CITY OF ALBUQUERQUE

August 20, 2012

**Re: Boulders Phase II and III
Grading and Drainage Plan
Engineer's Stamp Date 7/26/2012 (B11/D001C)**

DRAWN BY  
DY  
DATE  
9-06-12  
DRAWING  
OVERALL GRADING  
SHEET #  
**3**  
JOB #  
2011005

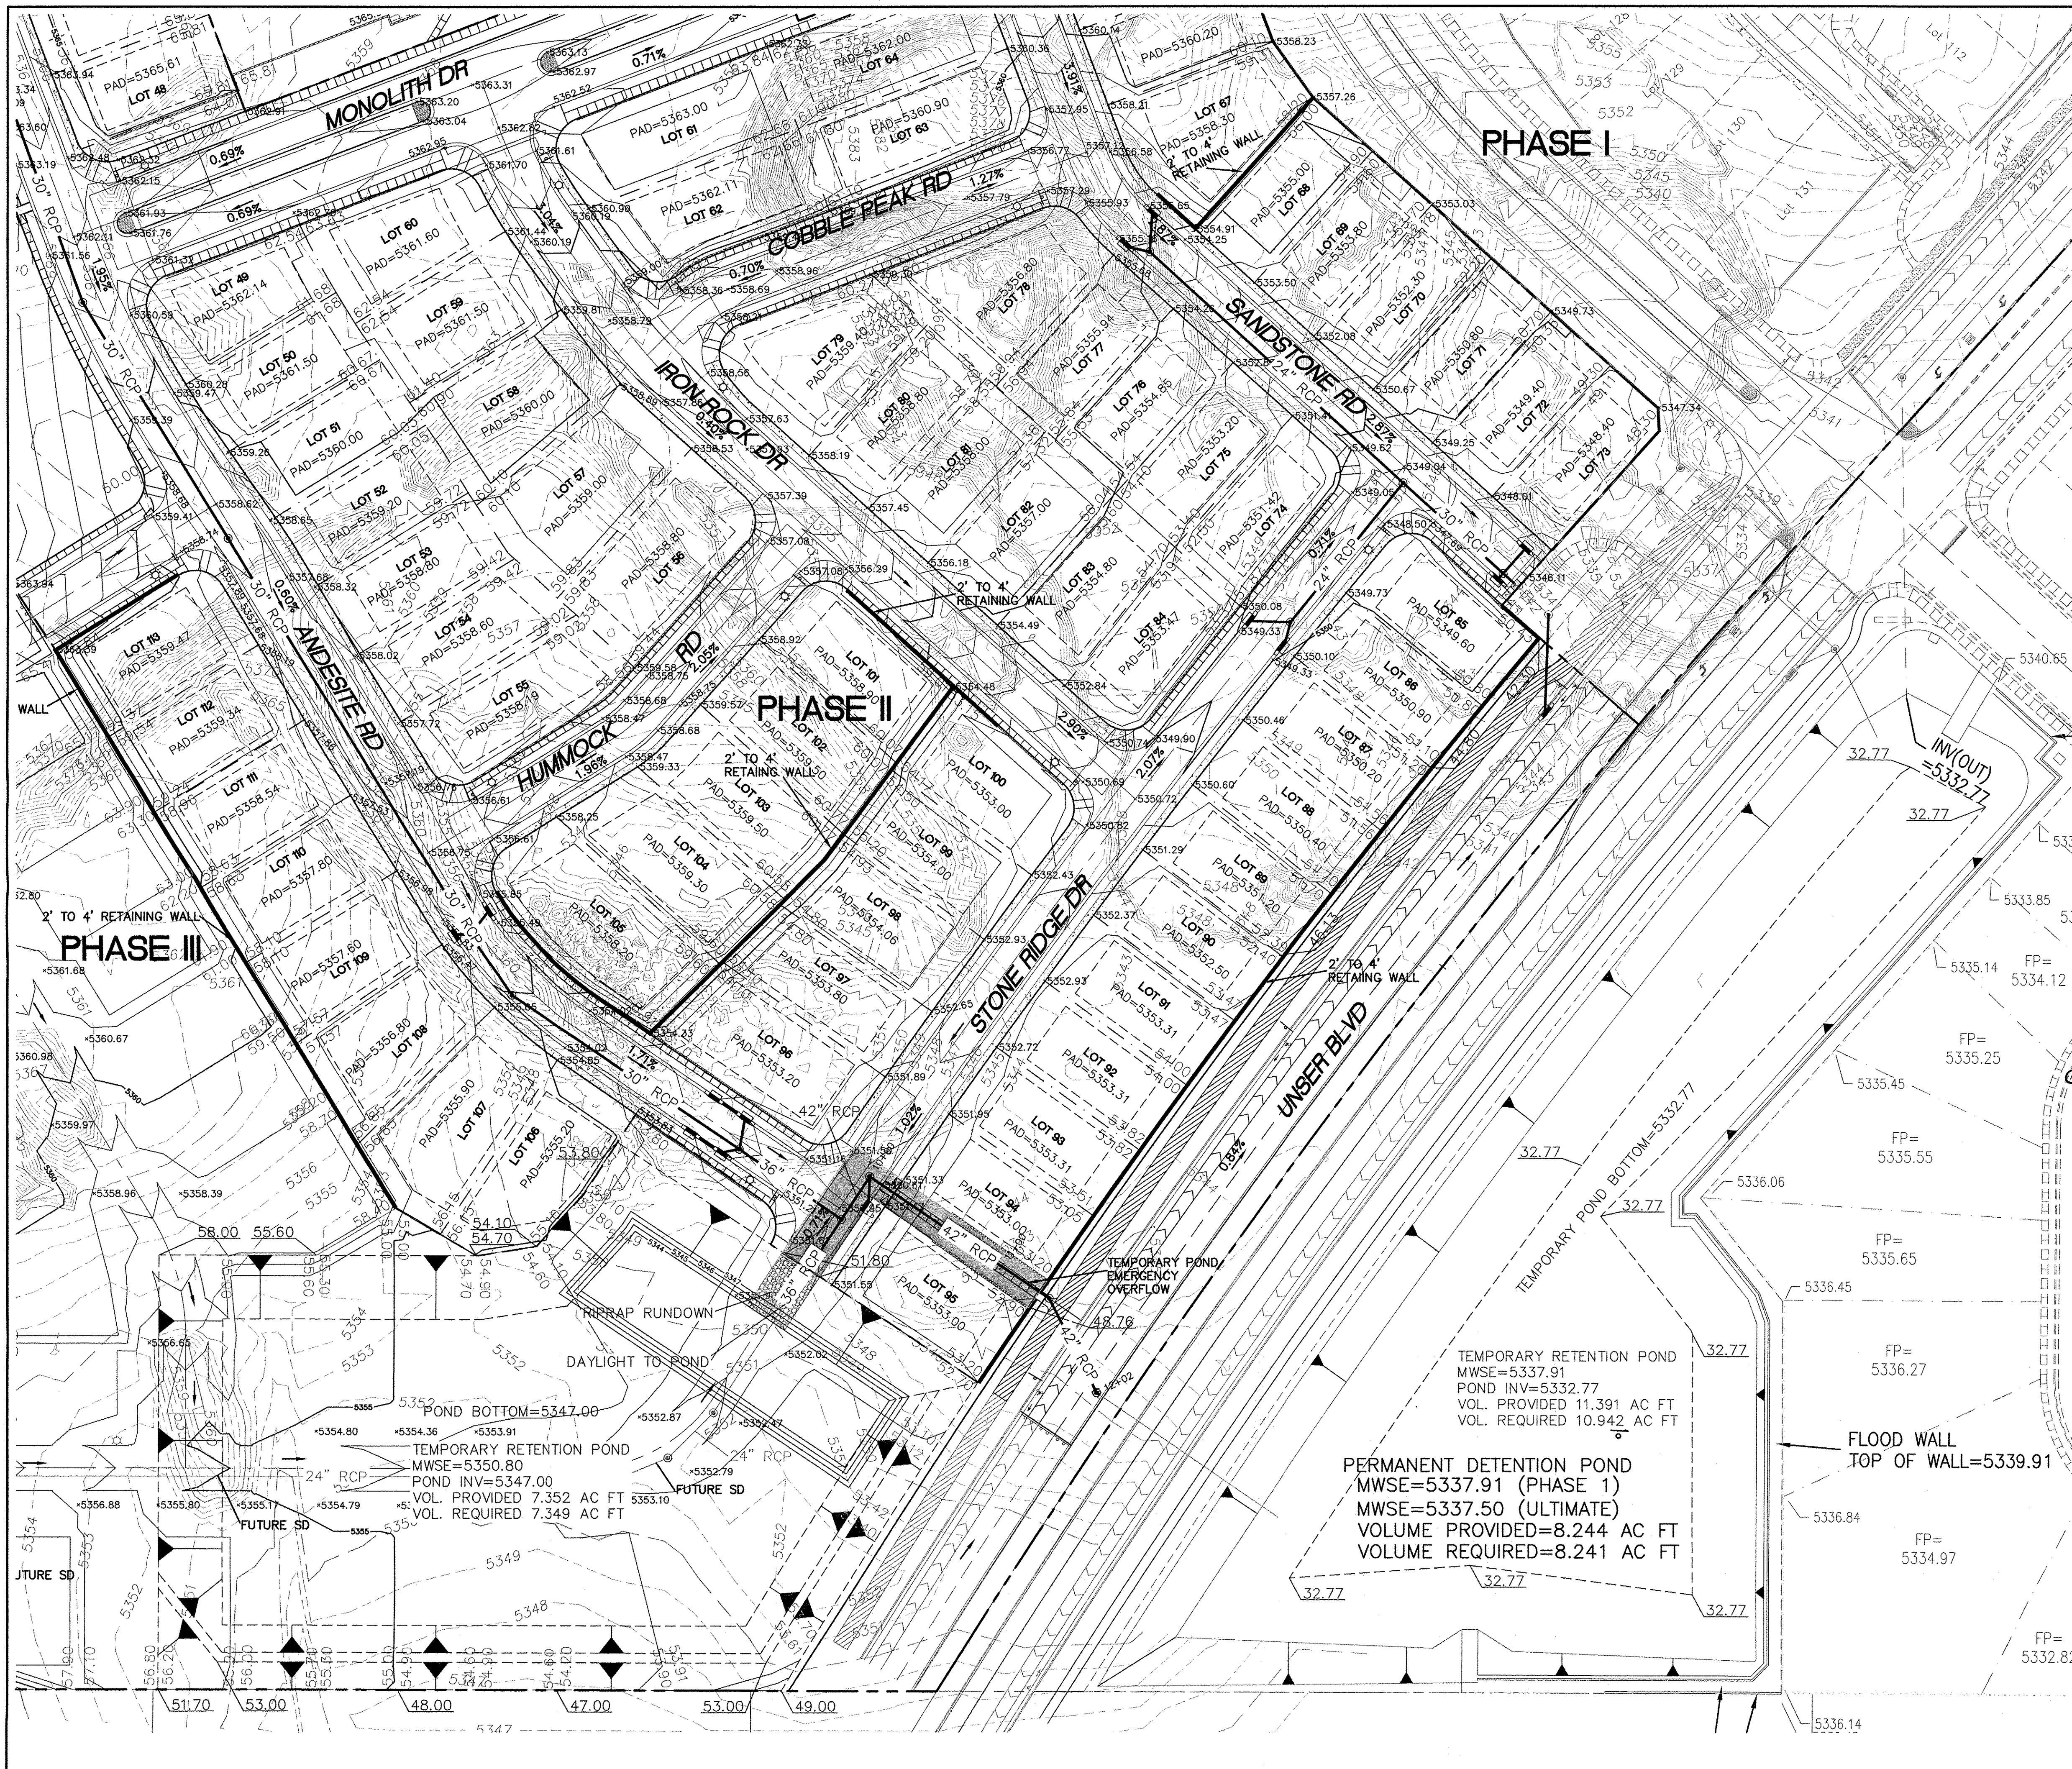
- Please plot the plans on a larger scale (1"=50').
- Add existing elevations along the property lines.
- Provide grades and slopes along the centerline of the streets.
- Street capacity analysis was not provided for Phases II and III.
- Include storm drainage calculations for the proposed inlets, storm drain pipes, and other drainage structures.
- Add lot numbers.
- Provide sections for the retention pond.
- More detail is required for the portion of the storm drain being proposed through the retention pond. What portions of the storm drain will be built? Provide a copy of the proposed plat and infrastructure list.
- Maintenance and Covenant will be required for the proposed retention pond.
- Have the grades been certified for the retention pond east of Unser Blvd.?
- Additional comments may be provided when the revised plan is submitted.
